Dear Andrew

Thank you for consulting the Conservation and Design Team on the above application.

There have been long-standing concerns about the proposal to site the school in this location with particular concerns about the relationship between the taxiway, the runway and the aircraft hangars. There was earlier discussion about a proposal to incorporate the school buildings within the aircraft hangar buildings and this would have been welcome, but was not acceptable from an educational point of view.

1. SITE STRATEGY - Constraints and Opportunities

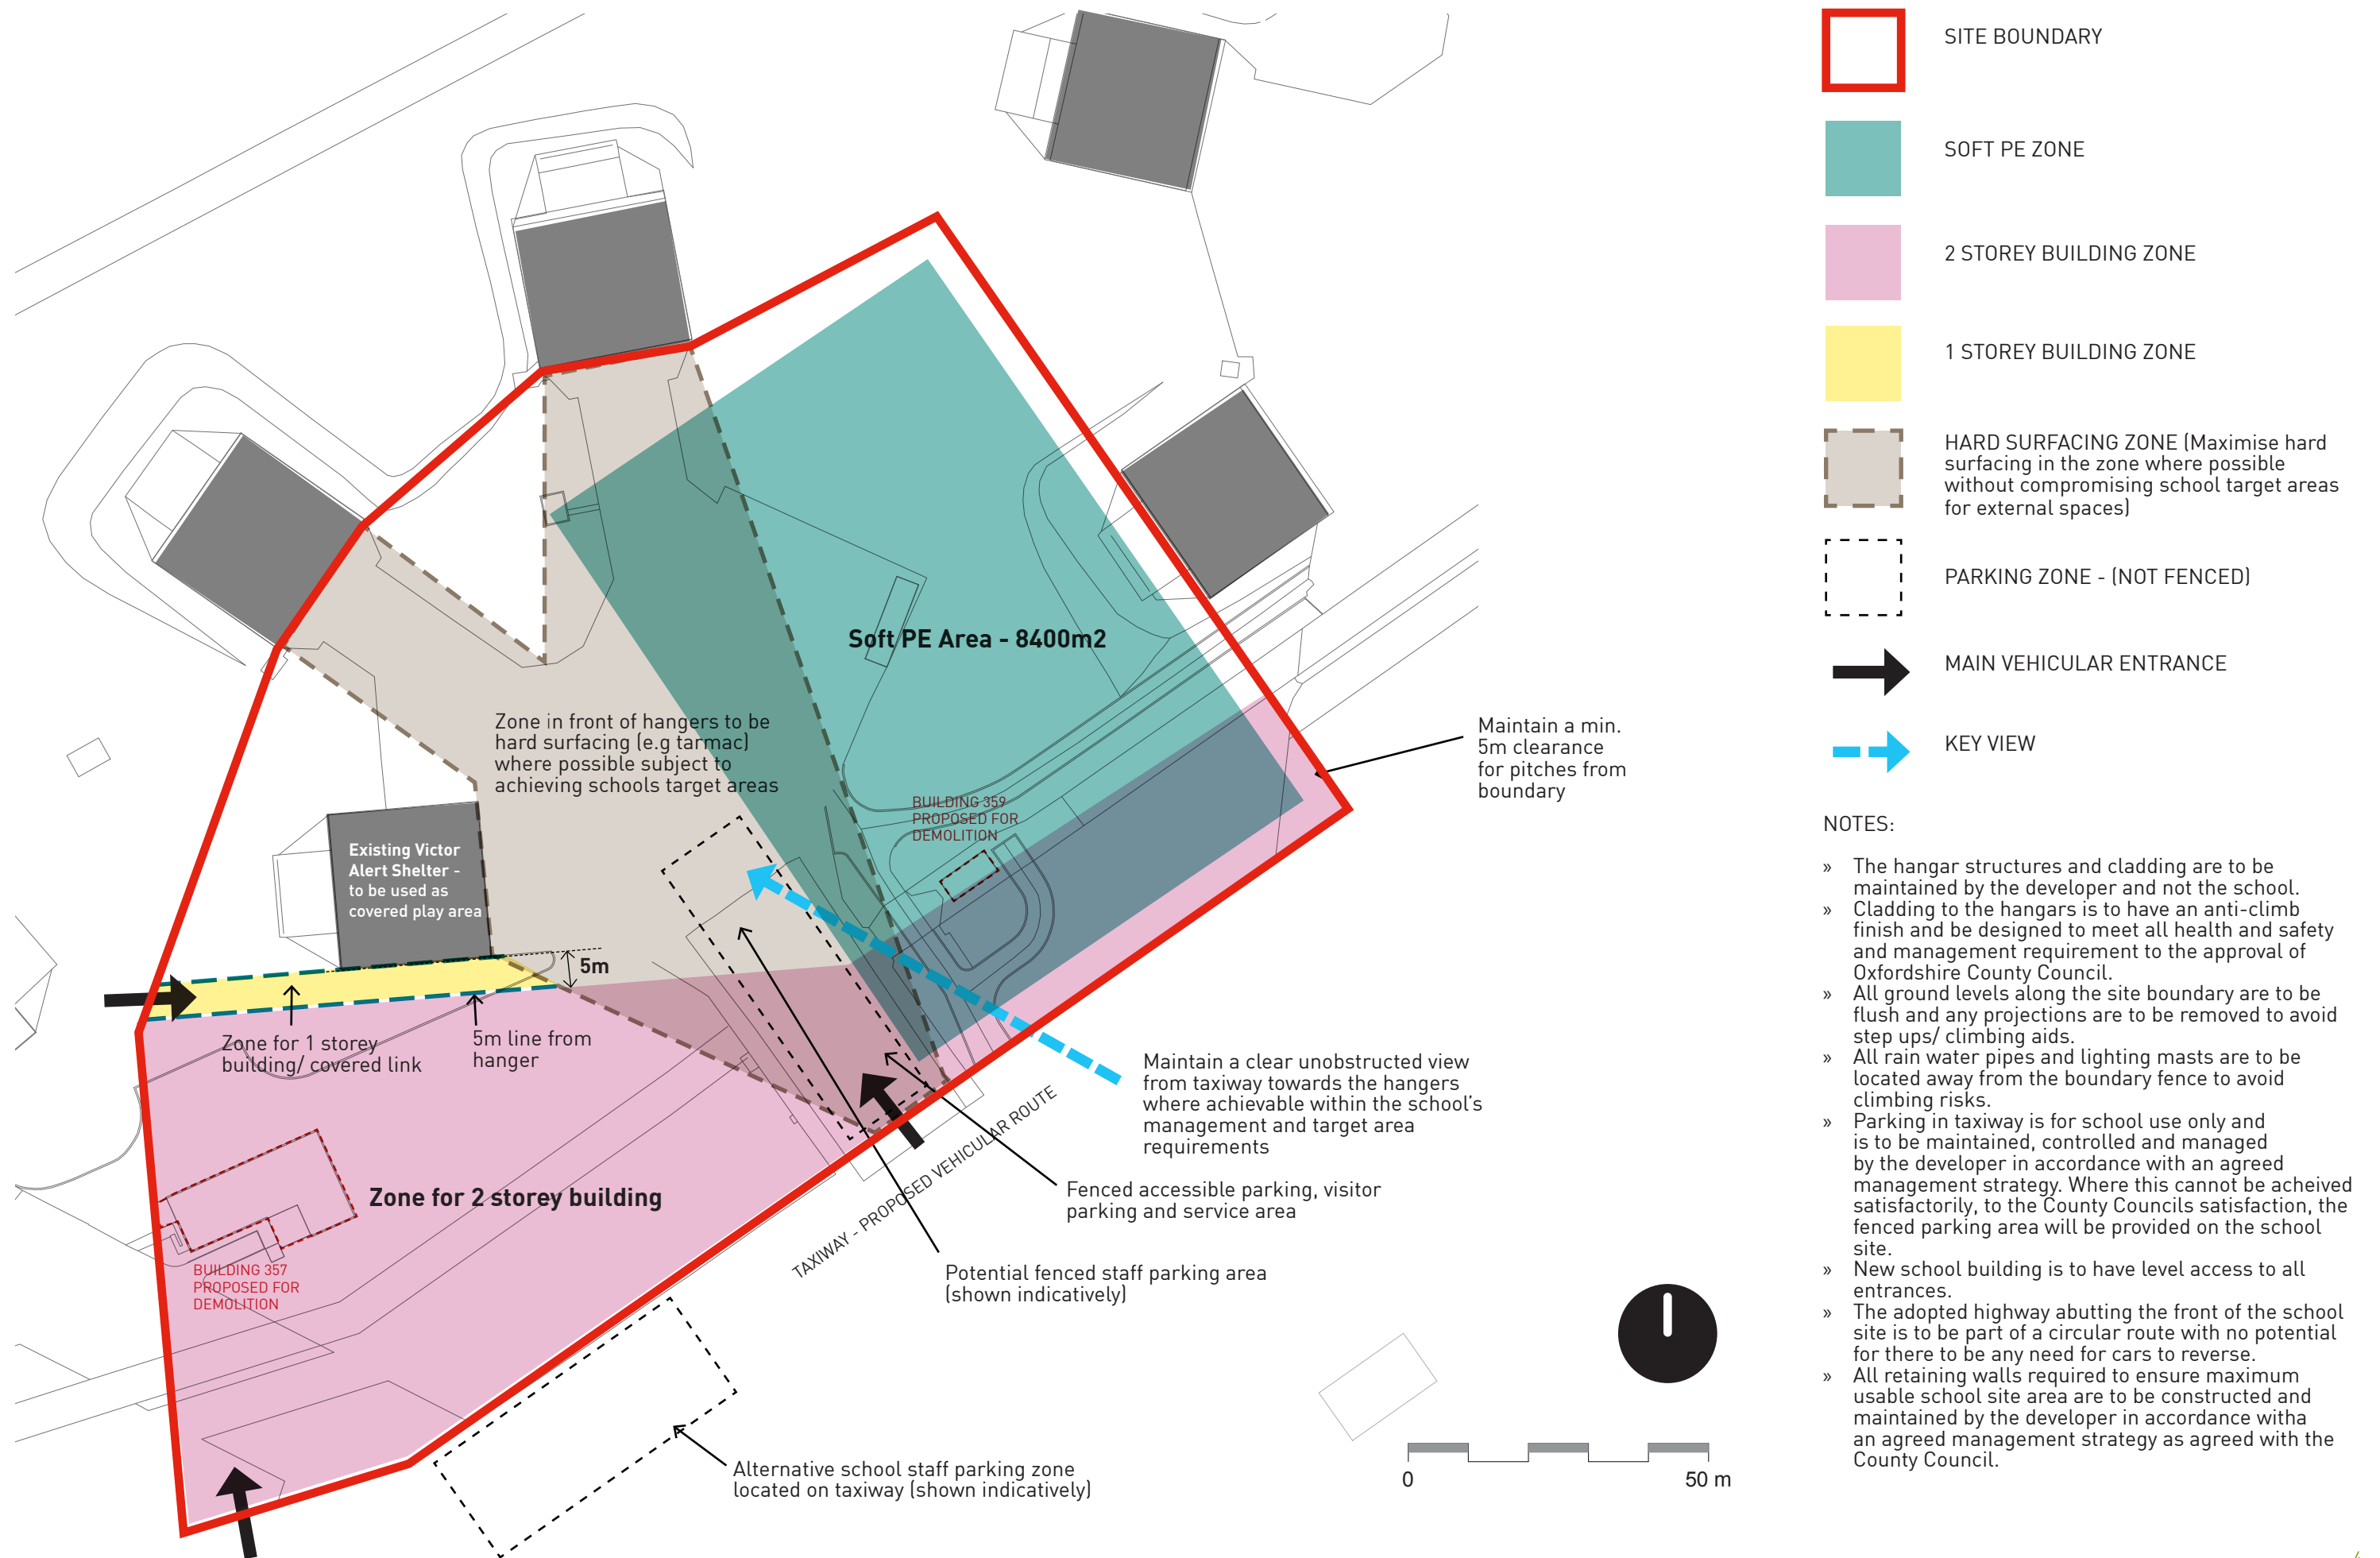
- The Heritage Impact Assessment document refers to a single storey link between the proposed new structure and building 2004. This has been discussed, but was part of a discussion about finding an appropriate relationship between the school building and the hangar. There is no indication of even the location of the school building (other than a 'zone' for building) and therefore the principle of the link should not be established at this stage.
- The zone for the single storey building / link should be removed from the plans in Design Revision B. A link of the size / scale indicated on this plan would not be acceptable. It should also be noted that this zone also corresponds with the main vehicular entranceway.
- It is unclear what the 'buffer zone' on the constraints and opportunities plan is.

1. SITE STRATEGY - ZONED PARAMETERS PLAN

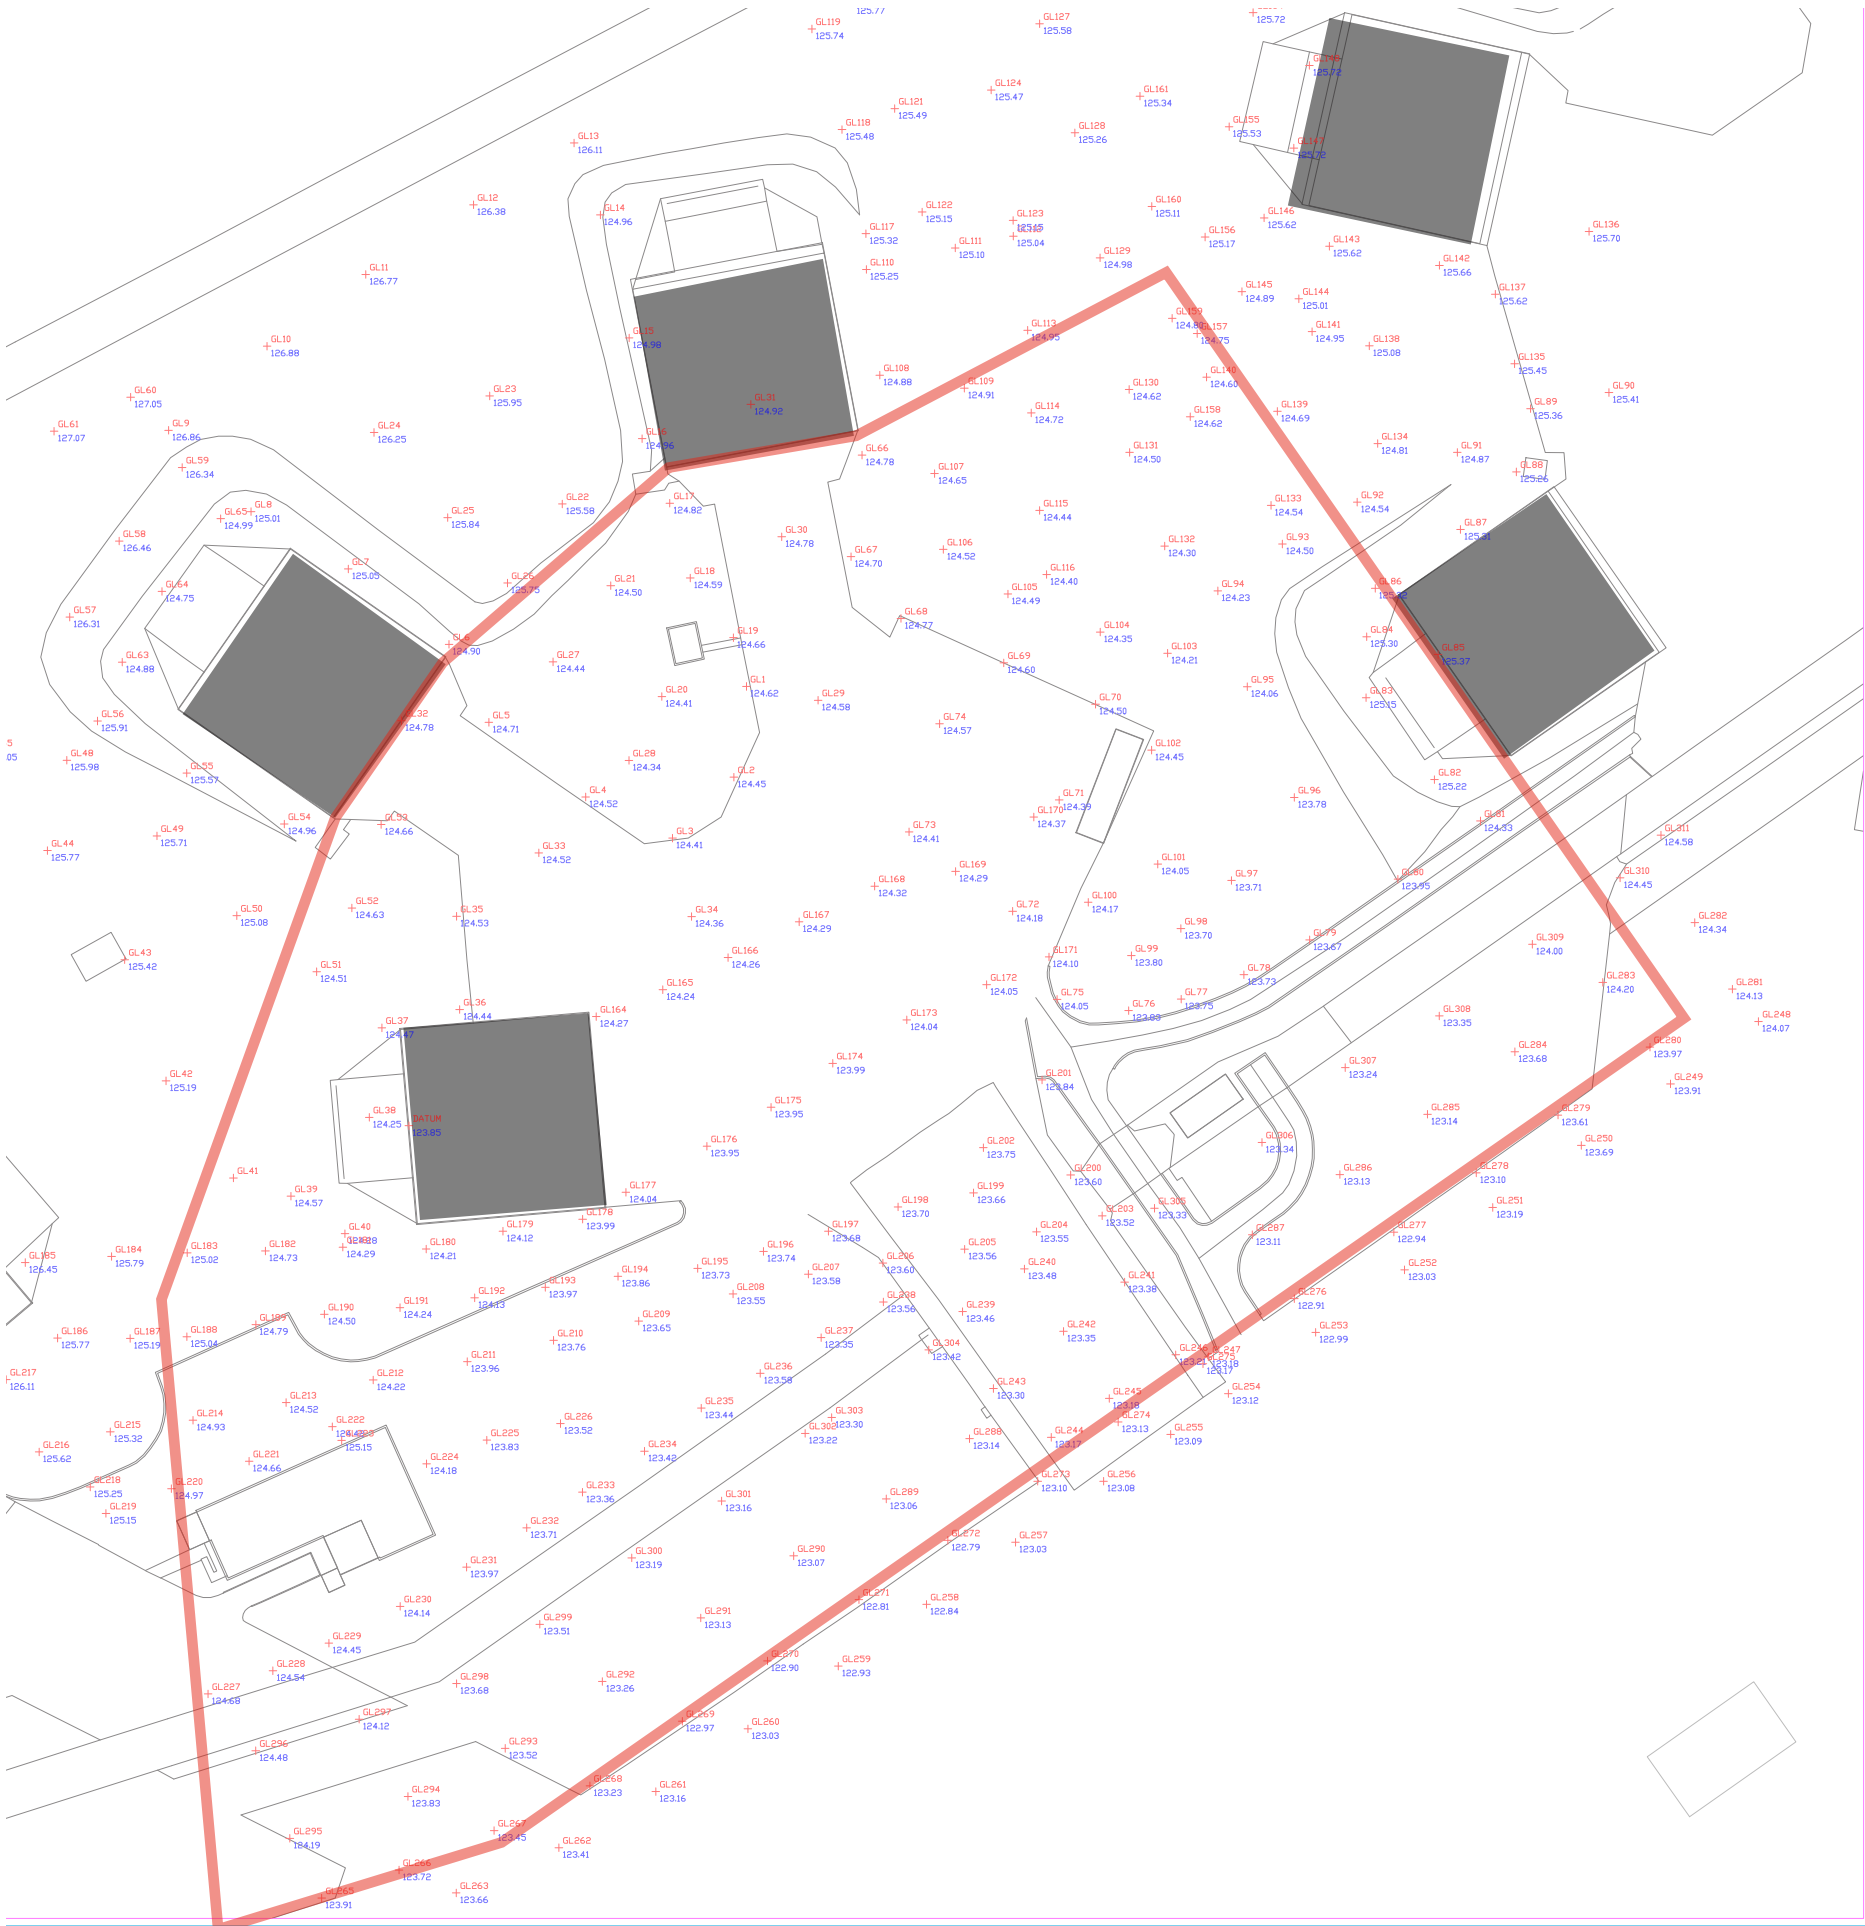
- There is more than just one viewpoint of significance between the taxiway and the hangars and this should be reflected on the parameters plan in Design Update Revision B.

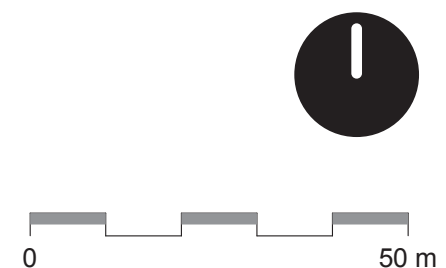
- Further details required about proposed 'modifications' to the Victor Alert Shelters which lie outside the school boundary will need to be justified. There may be concerns if there are alterations to the form of the building.
